FORD ROAD, ARUNDEL

PLANNING APPLICATION AB/54/22/DOC

SUDS MAINTENANCE STRATEGY COMMENTS

SECTION THROUGH RAISED STORAGE TANKS
BENEATH PROPOSED BUILDING FOOTPRINT
SCALE 1:50

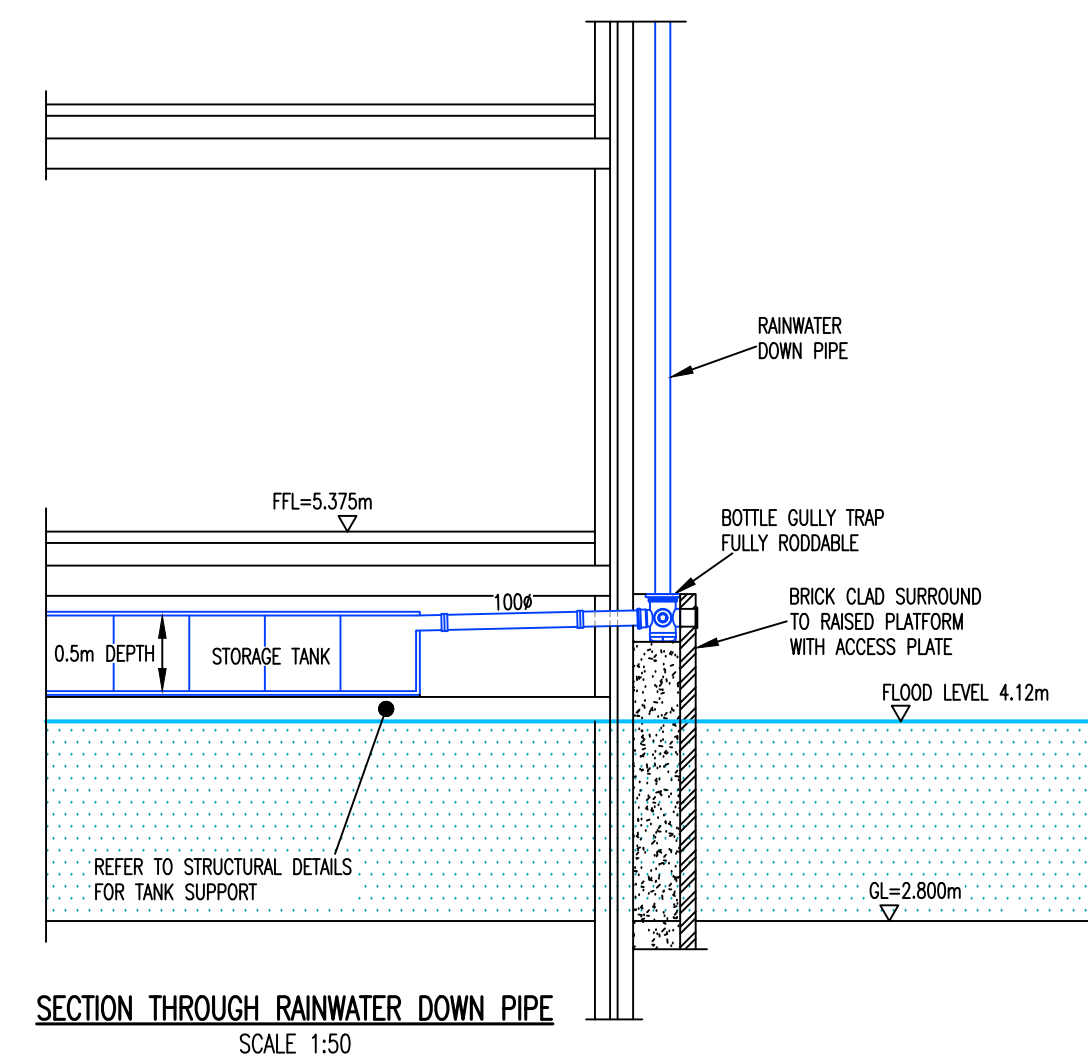
11. Maintenance for the suspended tank should also include details of how access under the voids (via the grating) will be provided to maintenance personnel. The Environment Agency often request voids to be sealed to prevent occupants from using these spaces to store personal items, which can affect their operation during periods of flooding. It should be considered whether locked access is required in this case. Further to this, maintenance of this tank and access to the void spaces will need to include consideration of health and safety aspects including whether this access constitutes a confined space, if other risks are present, and whether specialist permitting and training prior to access into this space is required.

The area where the above ground tanks are located are accessed via locked gates in the railing that close off the voids below the buildings. All the voids are a full storey in height and have a minimum of two large openings to allow ventilation. Therefore no restricted space training etc. is required.

Section P3-P3

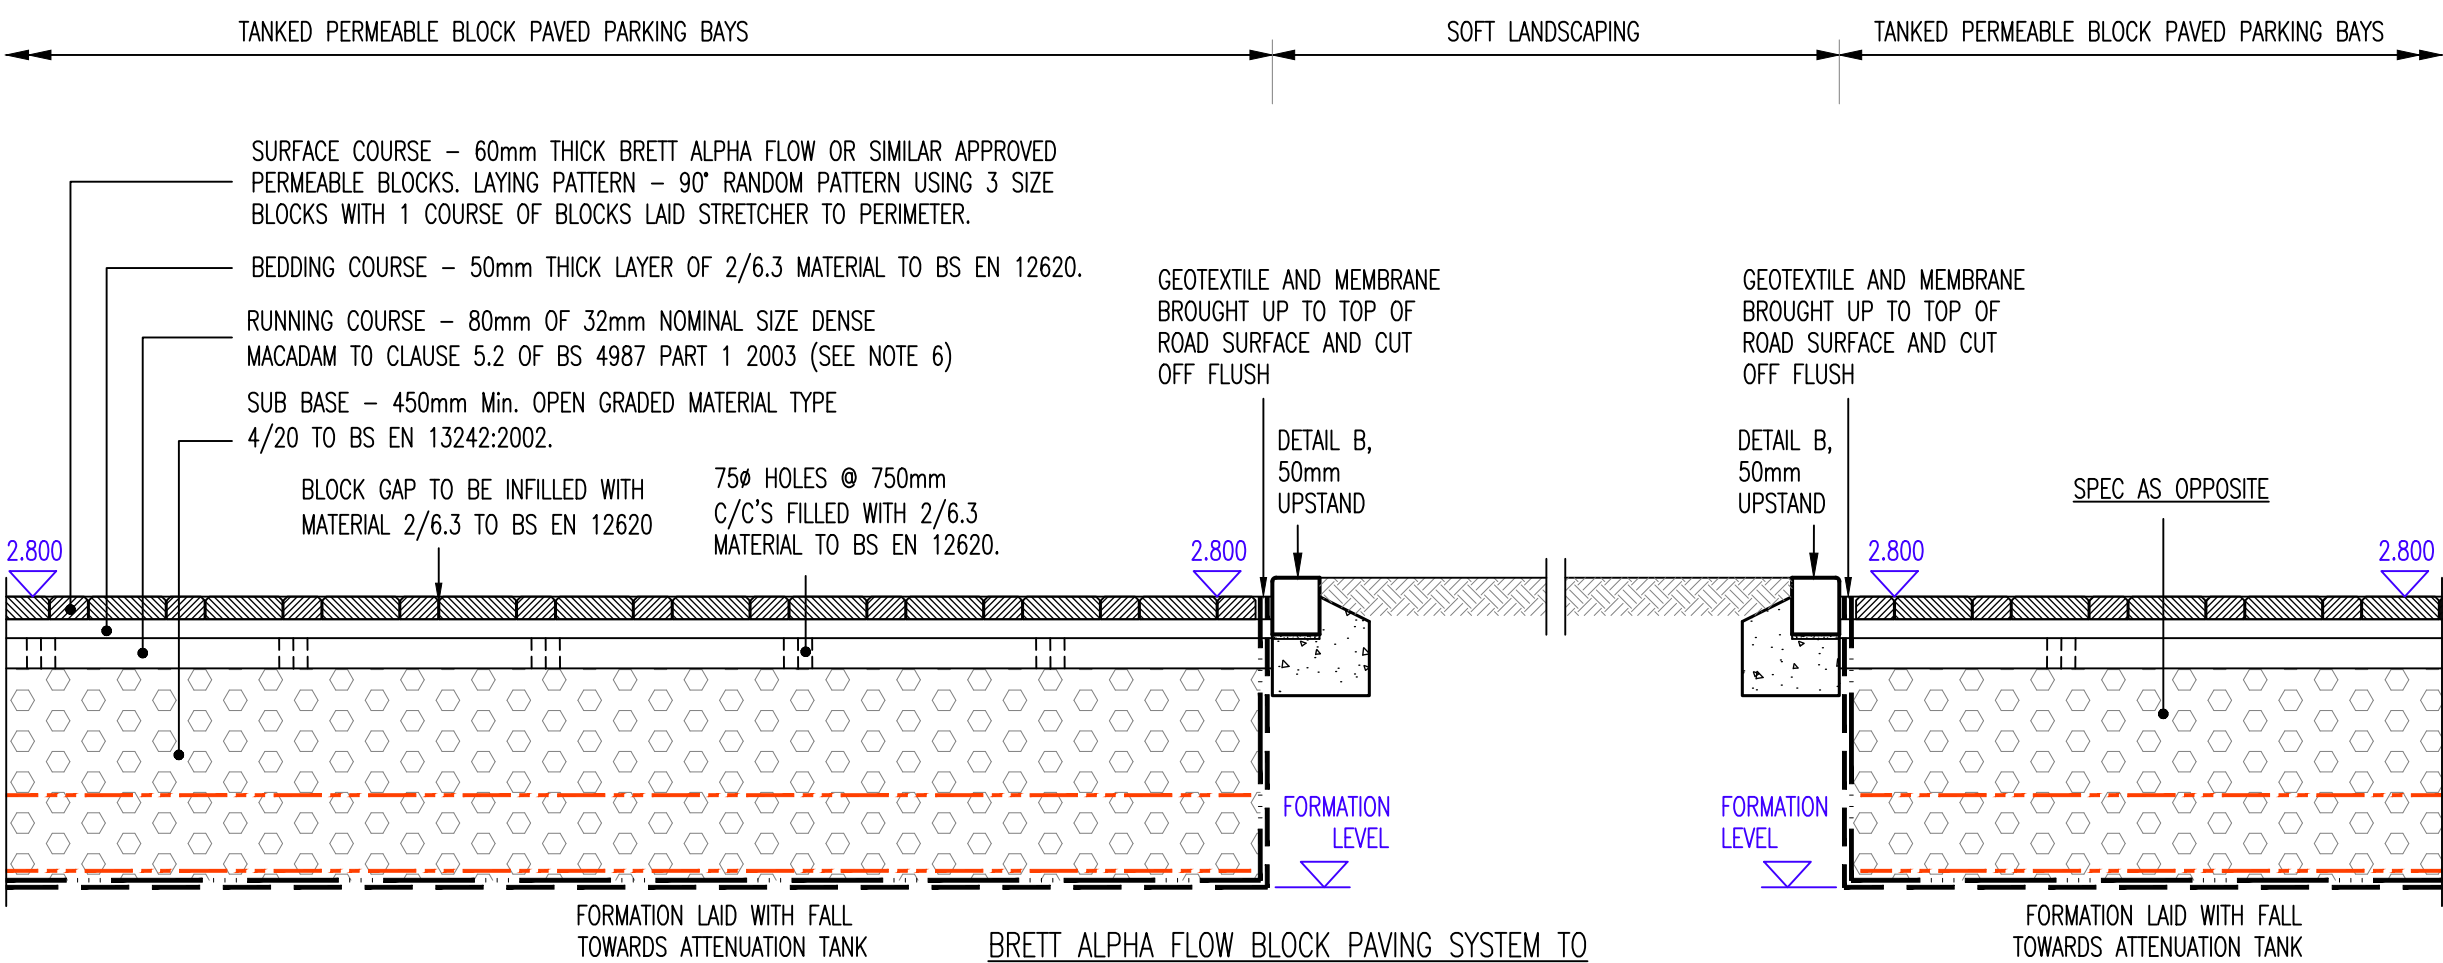
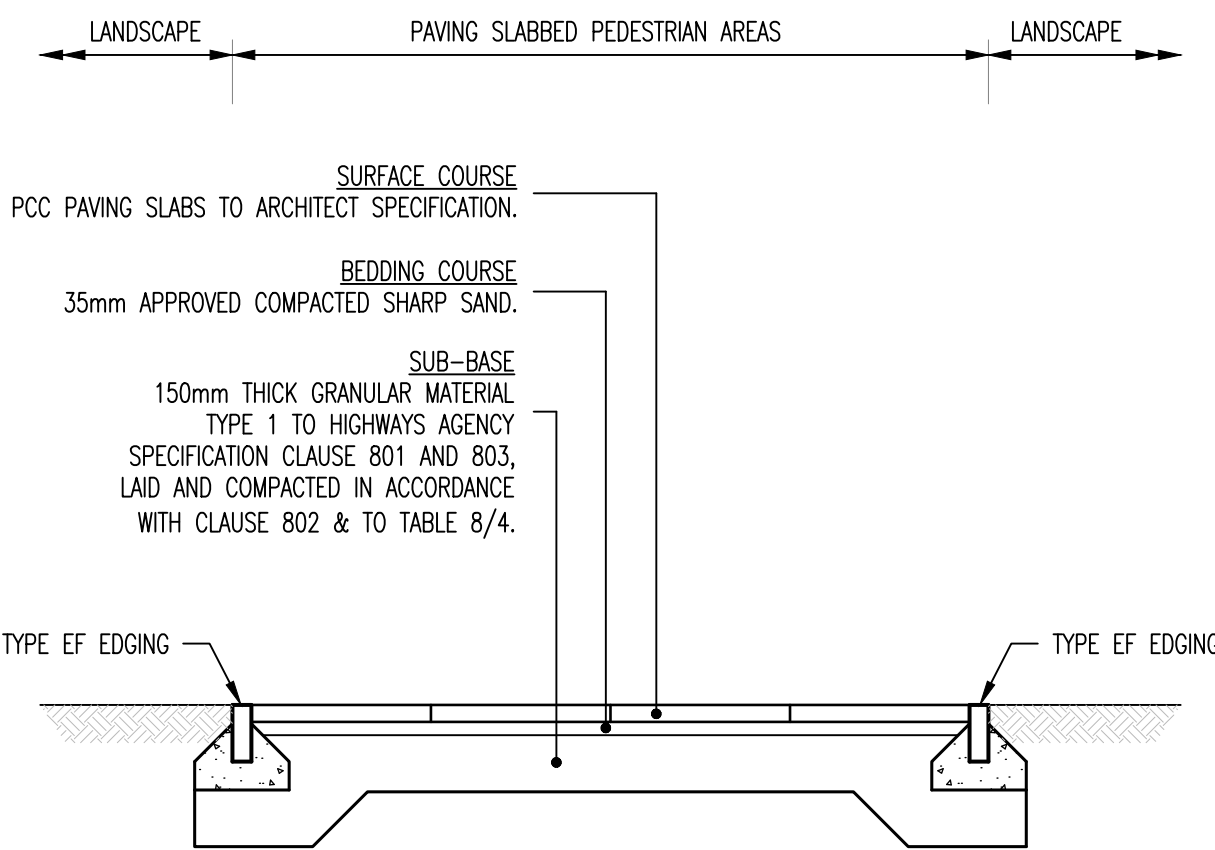
2. Please include an additional line confirming that the jointing aggregate should be replaced and that particular attention to the possible removal of this aggregate needs to be paid if jetting and suction equipment is removed. *(If the evidence listed above or type of surfacing used does not require this to be carried out this comment can be withdrawn).*

The Brett permeable paving system does have jointing aggregate and therefore as part of the maintenance regime will need topping up.
